## 70 Anderson St Survey Review 9 22 2016

Here is my review of the Site Plan dated 8 15 2016.

DRAWING NO. **C-10**

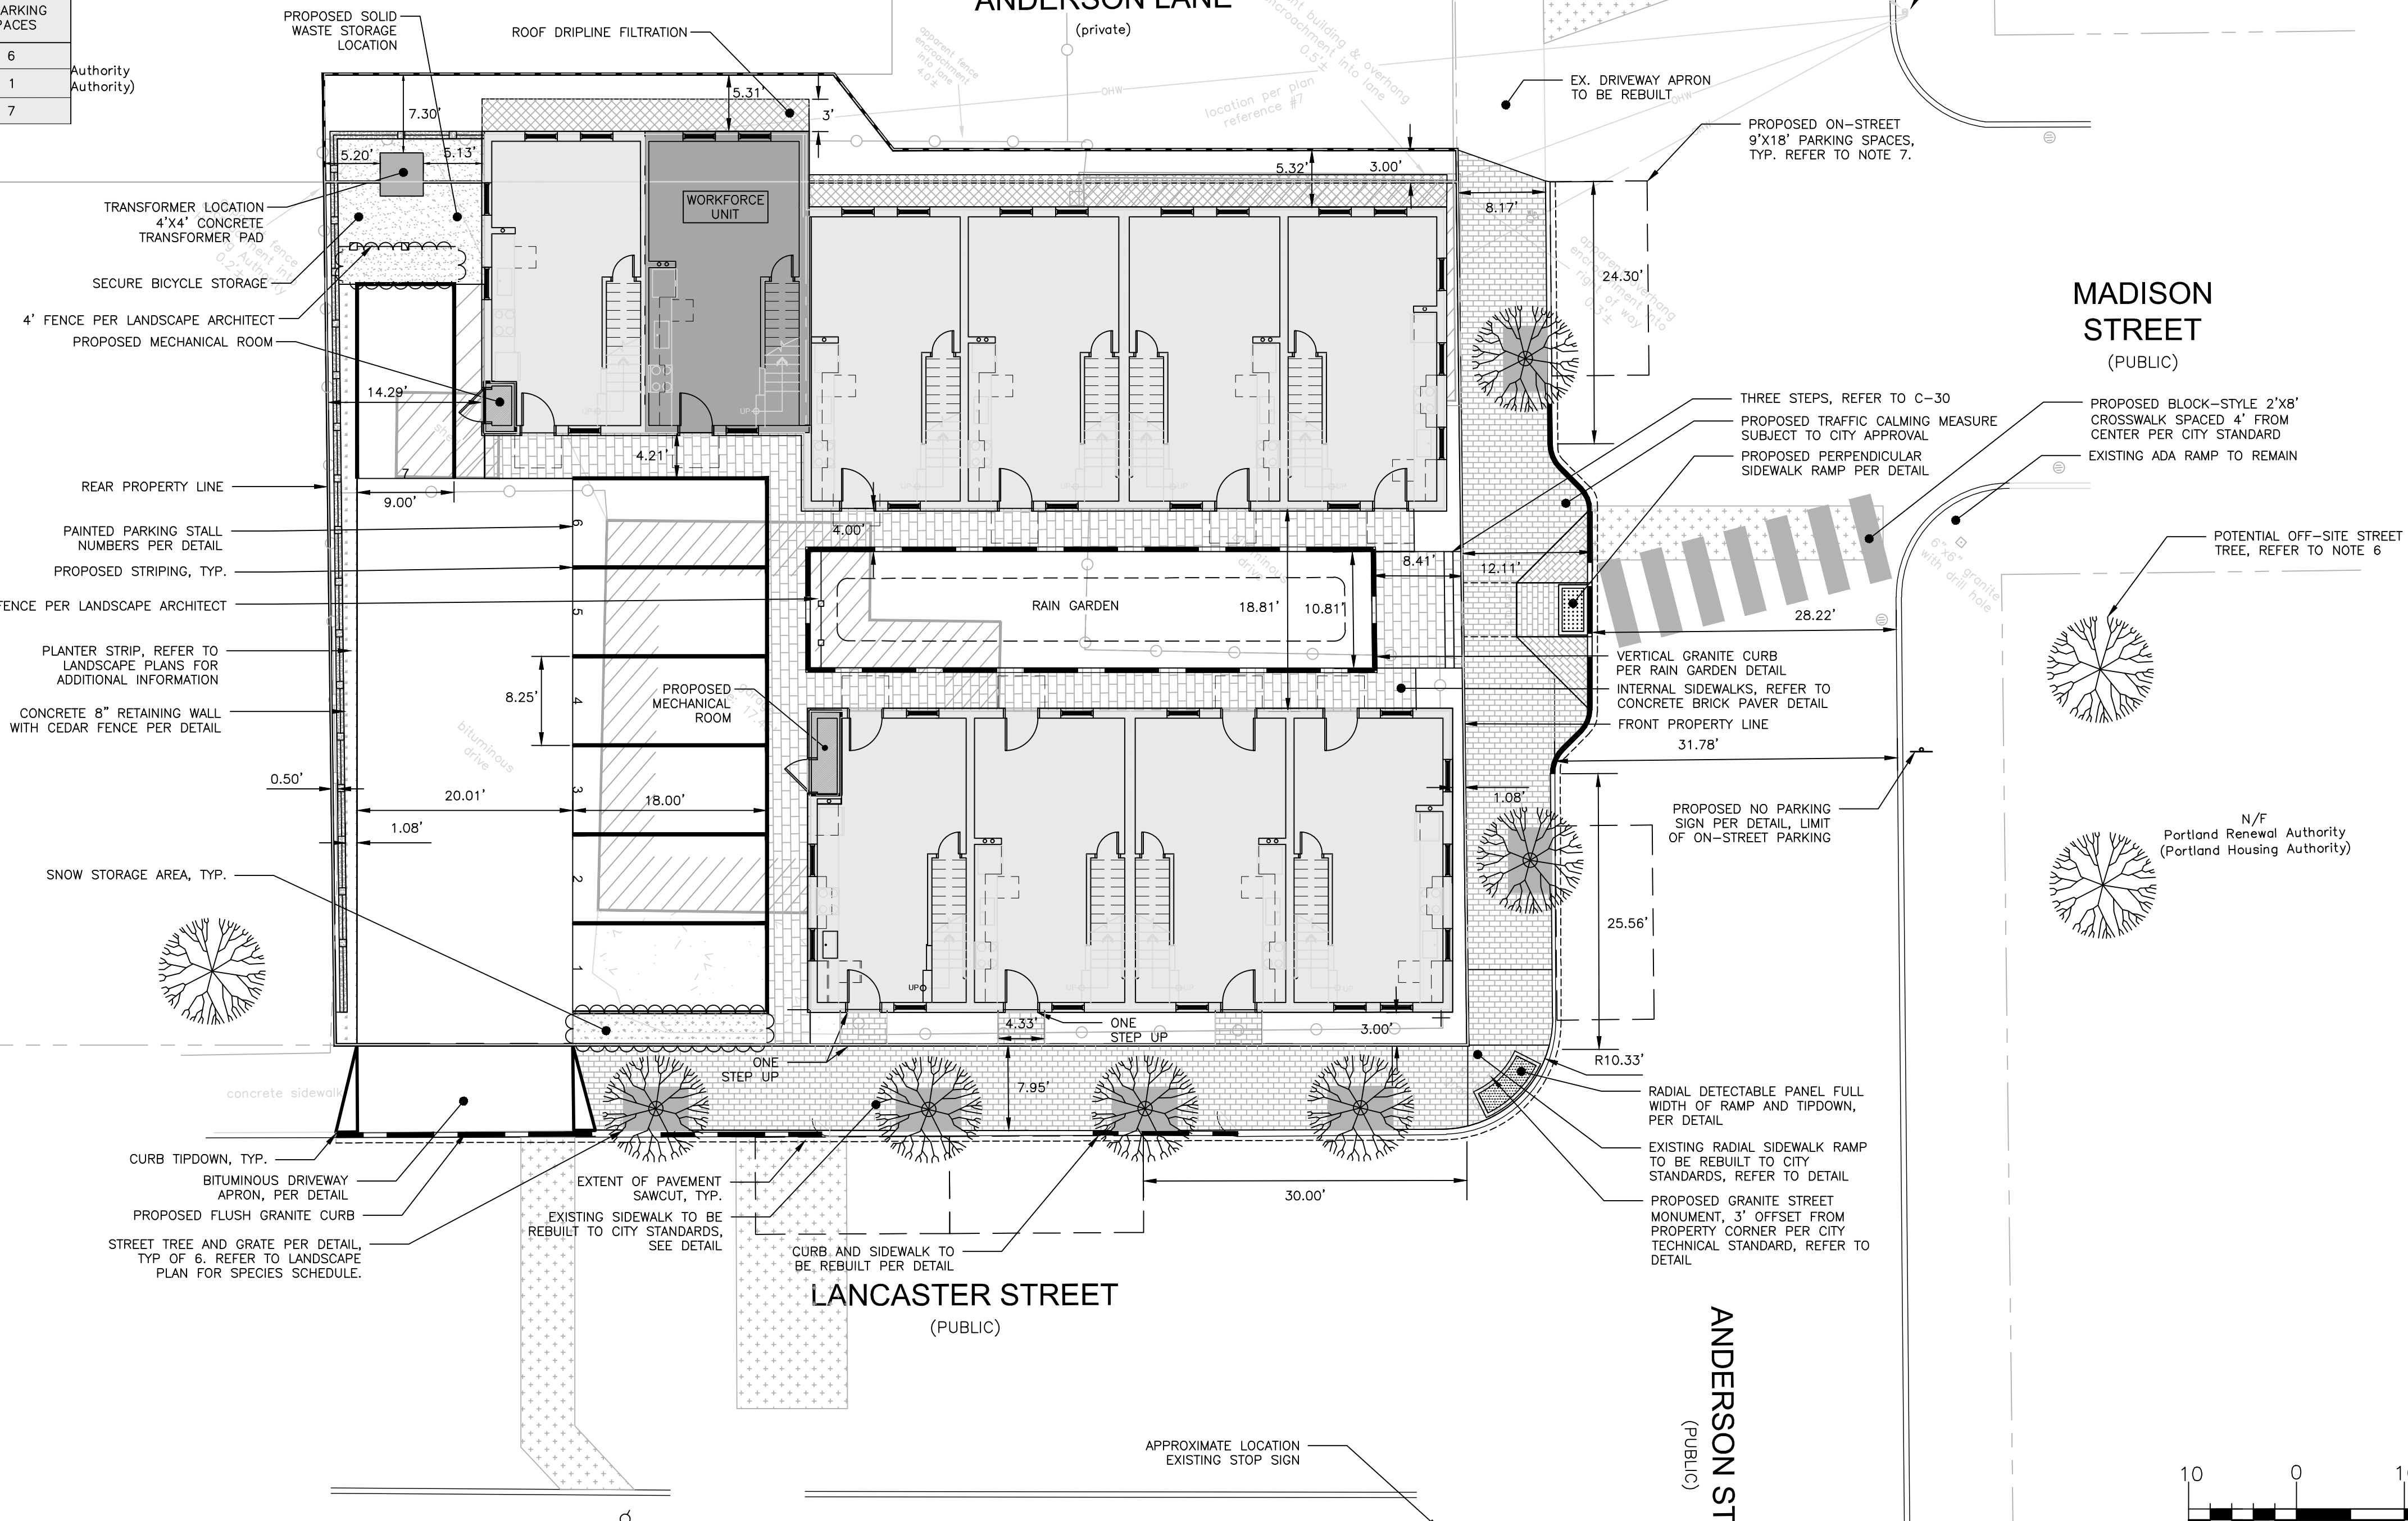
1. Need to show property corners to set as requested in my 7/12/2016 review.
2. Proposed Granite Monument to set is not shown.
3. As discussed the Survey Note #5 states that Fee Interest in Anderson Lane apparently lies with the heirs of Moses Gould as described in a deed recorded in Book 290, Page 310. The unrecorded release deed from Portland Housing Authority to Redfern Properties does not state that the Portland Housing Authority acquired title from the heirs of Moses Gould. Barbara said she would talk with Corporation Counsel. I was just worried that this may come up in the future and cause problems for future owners. I defer to Corporation Counsel on this item.
4. Needs Stamp of the Professional Land Surveyor.
